**KIRKLEES METROPOLITAN COUNCIL
INVESTMENT & REGENERATION SERVICE**

DELEGATED DECISION TO DETERMINE PLANNING APPLICATIONS

Reference No:	2024/62/90905/E
Site Address:	21, Summerbridge Crescent, Gomersal, Cleckheaton, BD19 4LW
Description:	Erection of front, side and rear extensions and alterations
Recommending Officer:	Jennifer Booth

DECISION – Conditional Full Permission

Drawing Title
 PROPOSED

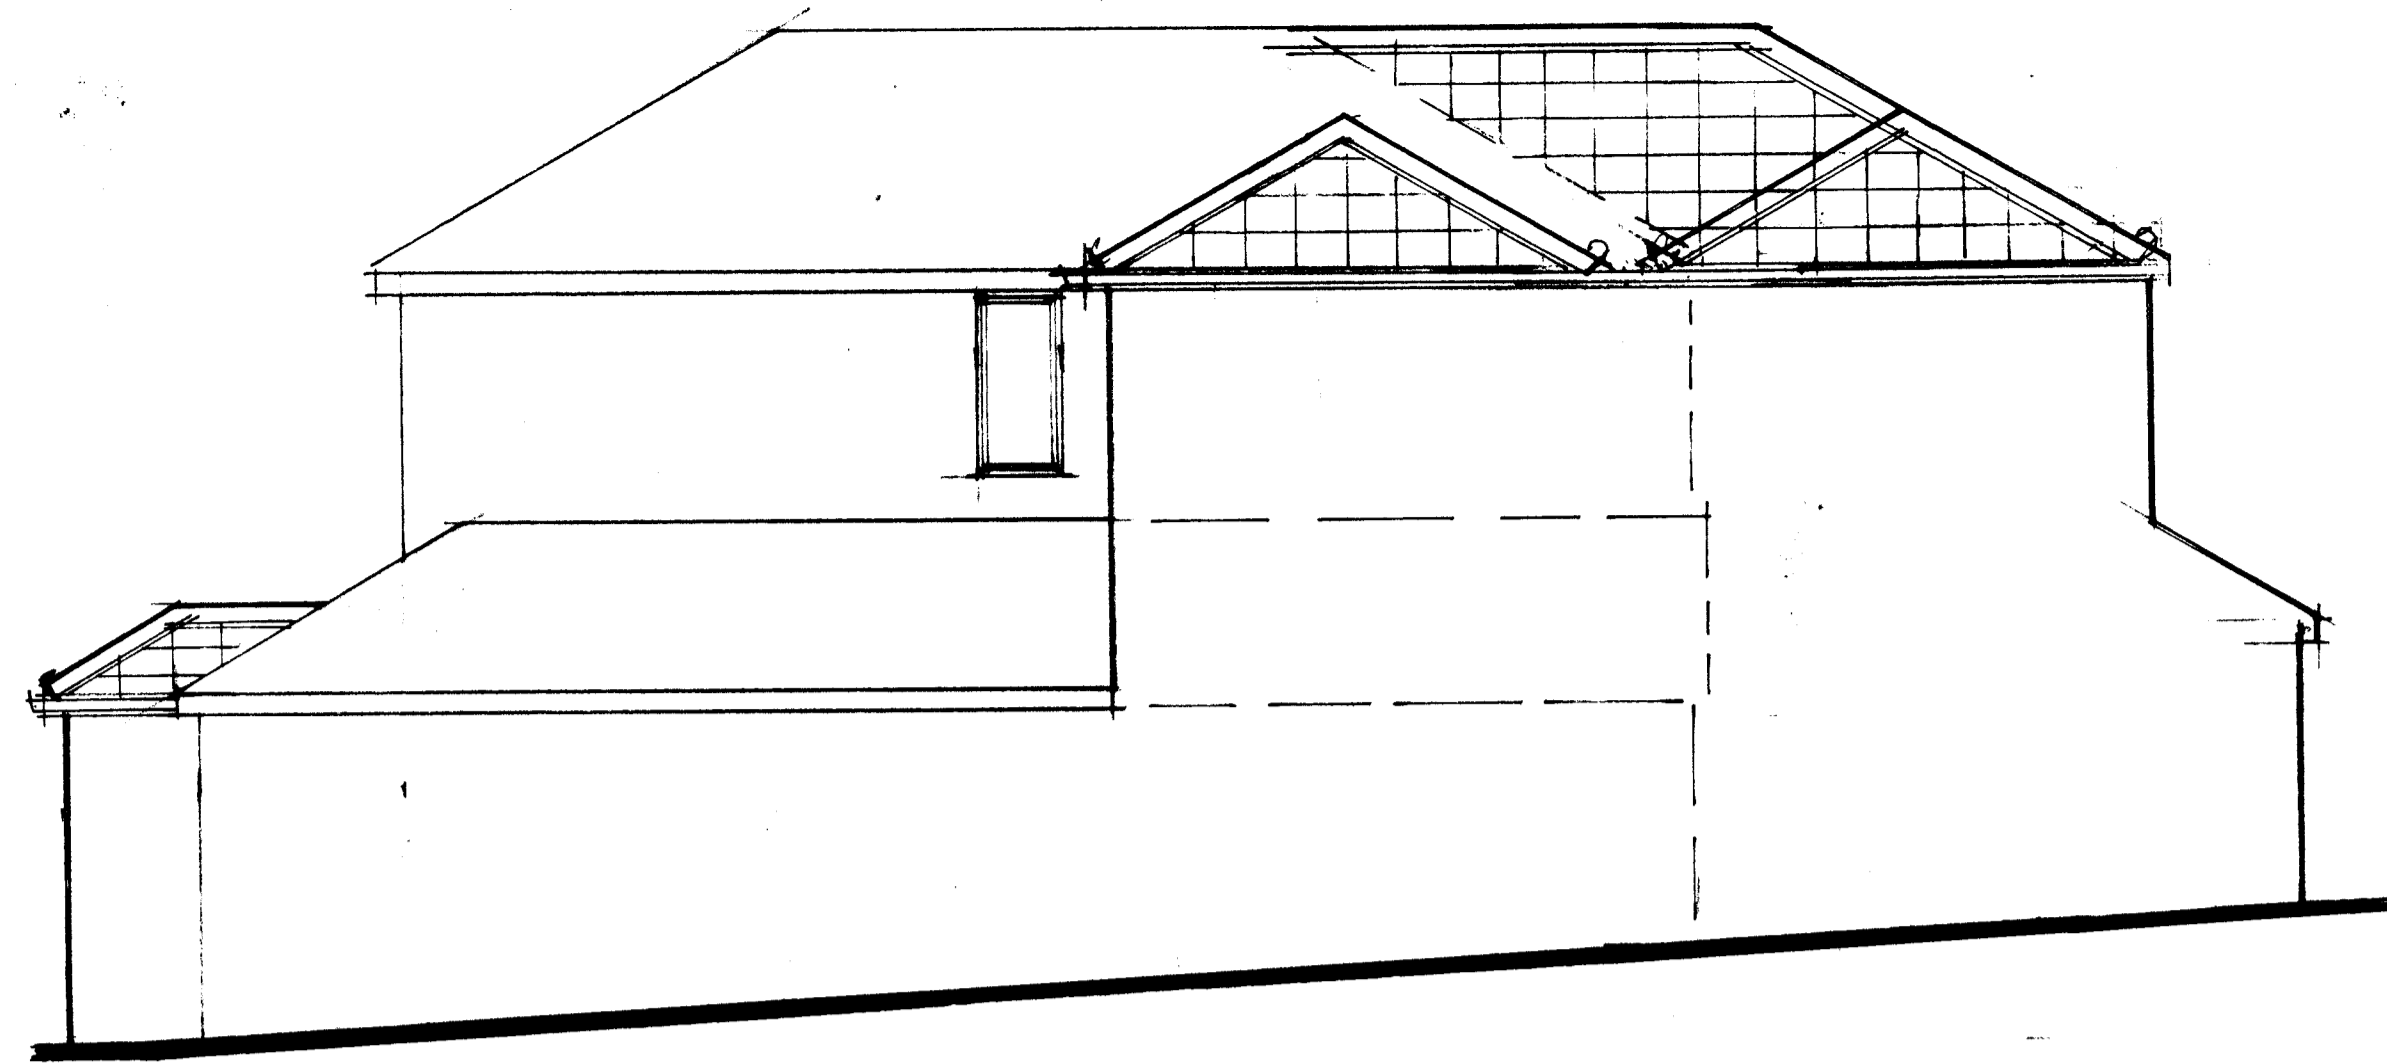
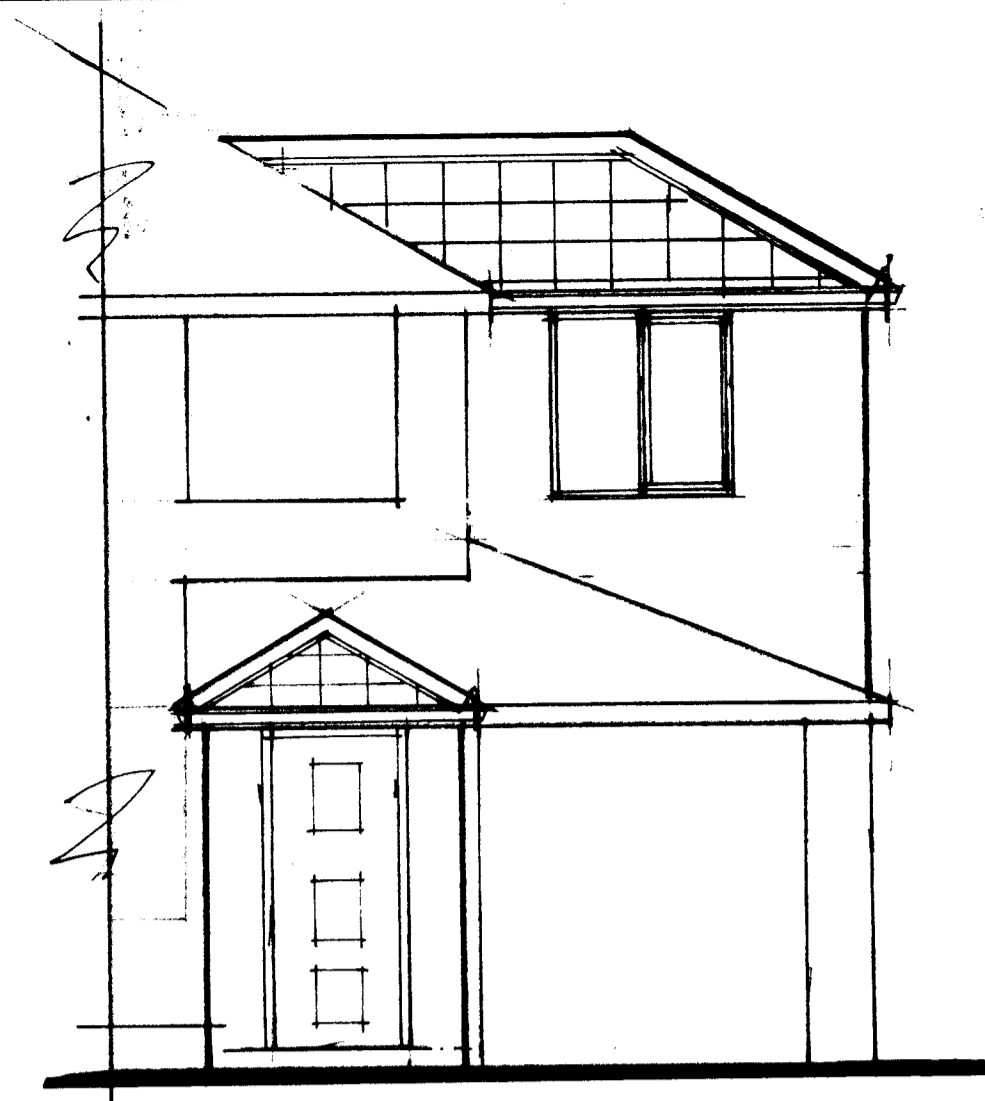
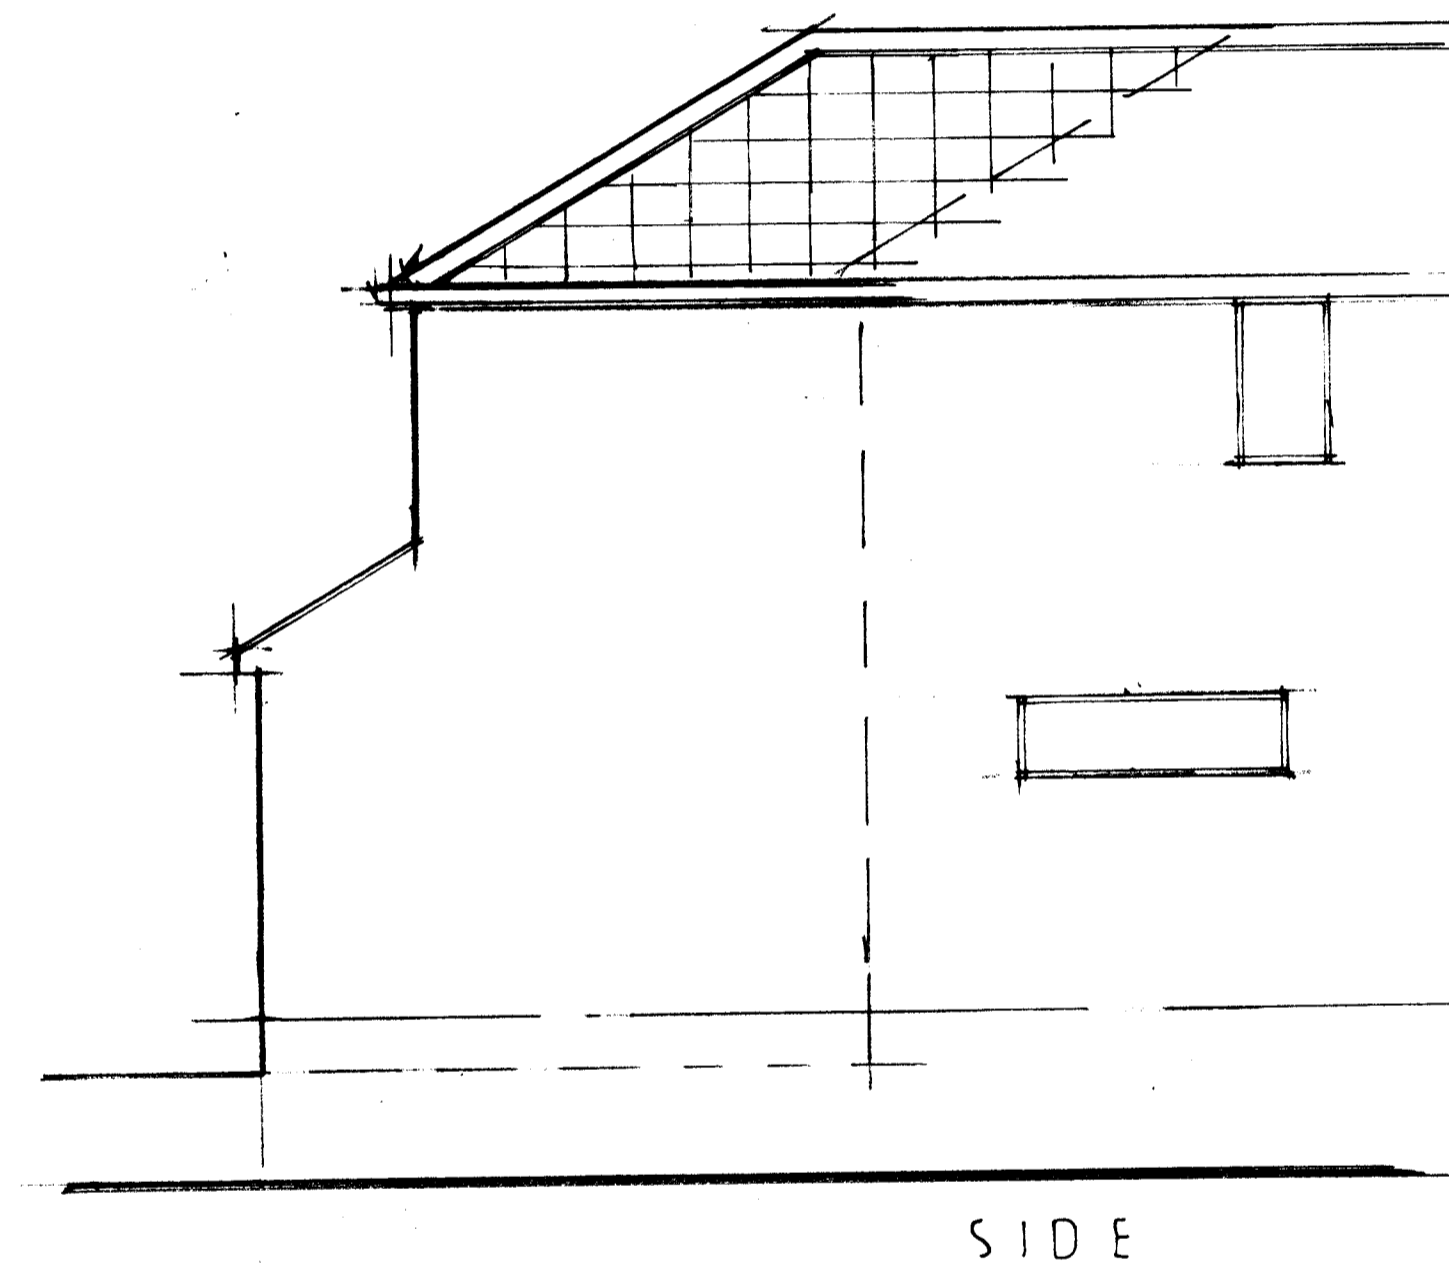
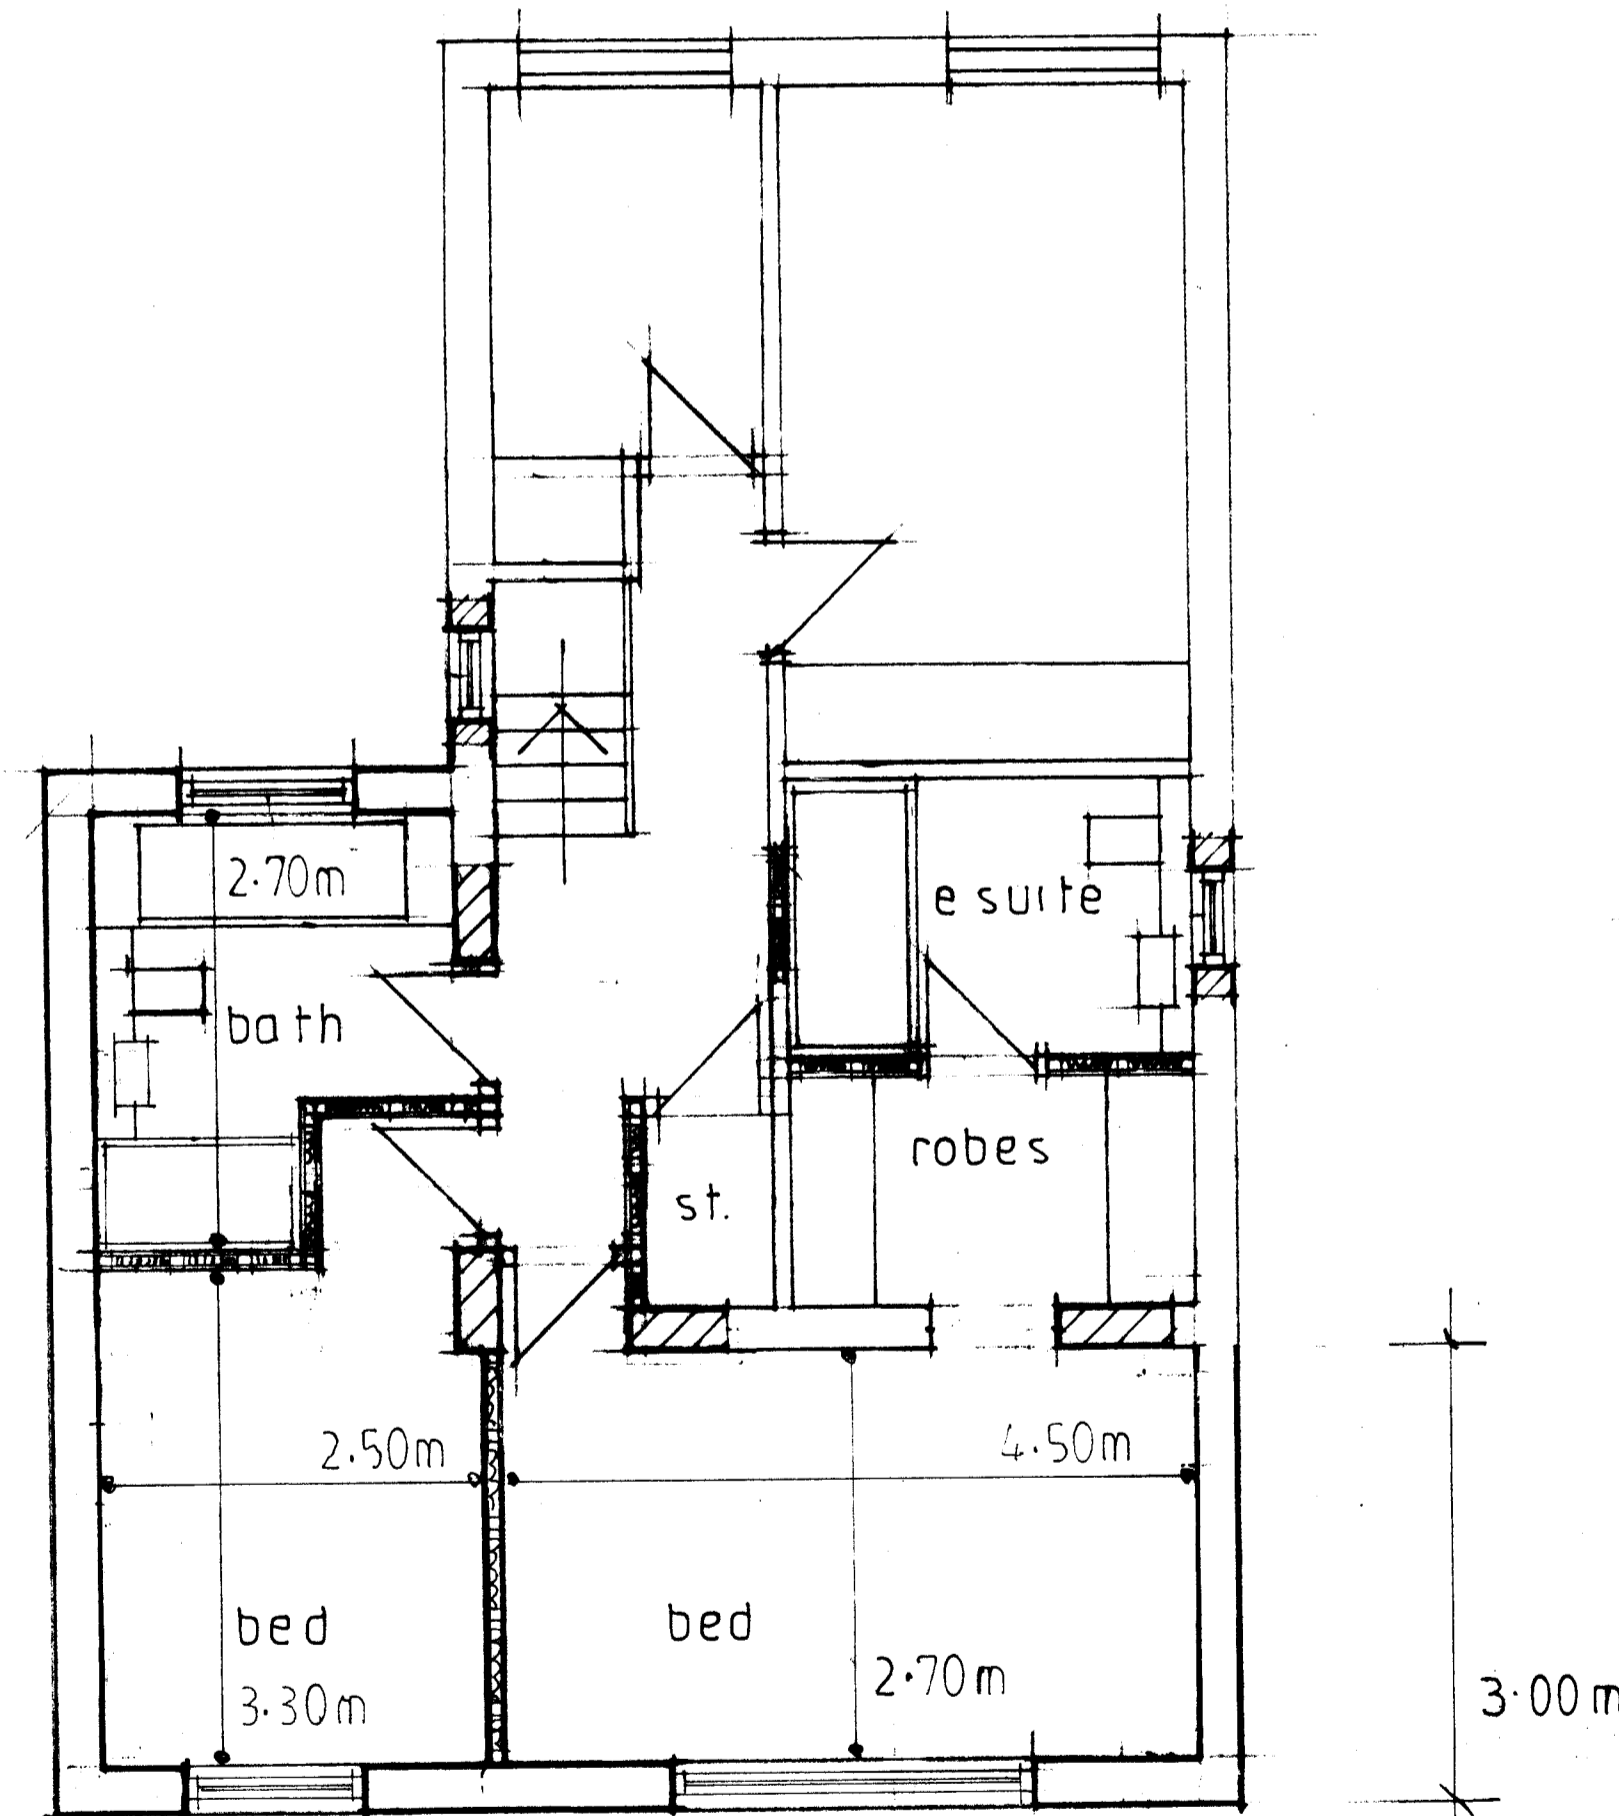
The plans as originally submitted raised concerns in terms of the potential impacts of a 2 storey extension with a projection of 4m on the adjacent dwelling. Amended plans were sought and received which reduced the projection at first floor to 3m. As the alteration reduced the scheme, the amended plans have not been advertised.

The rear extension would project 4m on the ground floor, reducing to 3m at first floor. Given the separation provided by the drive of the adjacent property together with the garage, the extension would result in negligible overshadowing or overbearing impact. The windows in the rear elevation would not result in any additional overlooking over and above the existing arrangements on site.

The neighbouring property occupies an elevated position relative to the neighbouring property and there is a lack of direct alignment together with significant angling between the properties. The side and rear extension would increase the bulk along the shared boundary with the adjacent bungalow. However, the first floor side extension aligns with the front corner of the neighbouring property. Furthermore, the spatial relationship between the properties mitigates against some of the impacts.

The plans initially submitted raised concerns in terms of potential impacts of a 2 storey extension with a projection of 4m on the adjacent dwelling. Amended plans were sought and received which reduced the projection at first floor to 3m. As the alteration reduced the scheme, the amended plans have not been advertised.
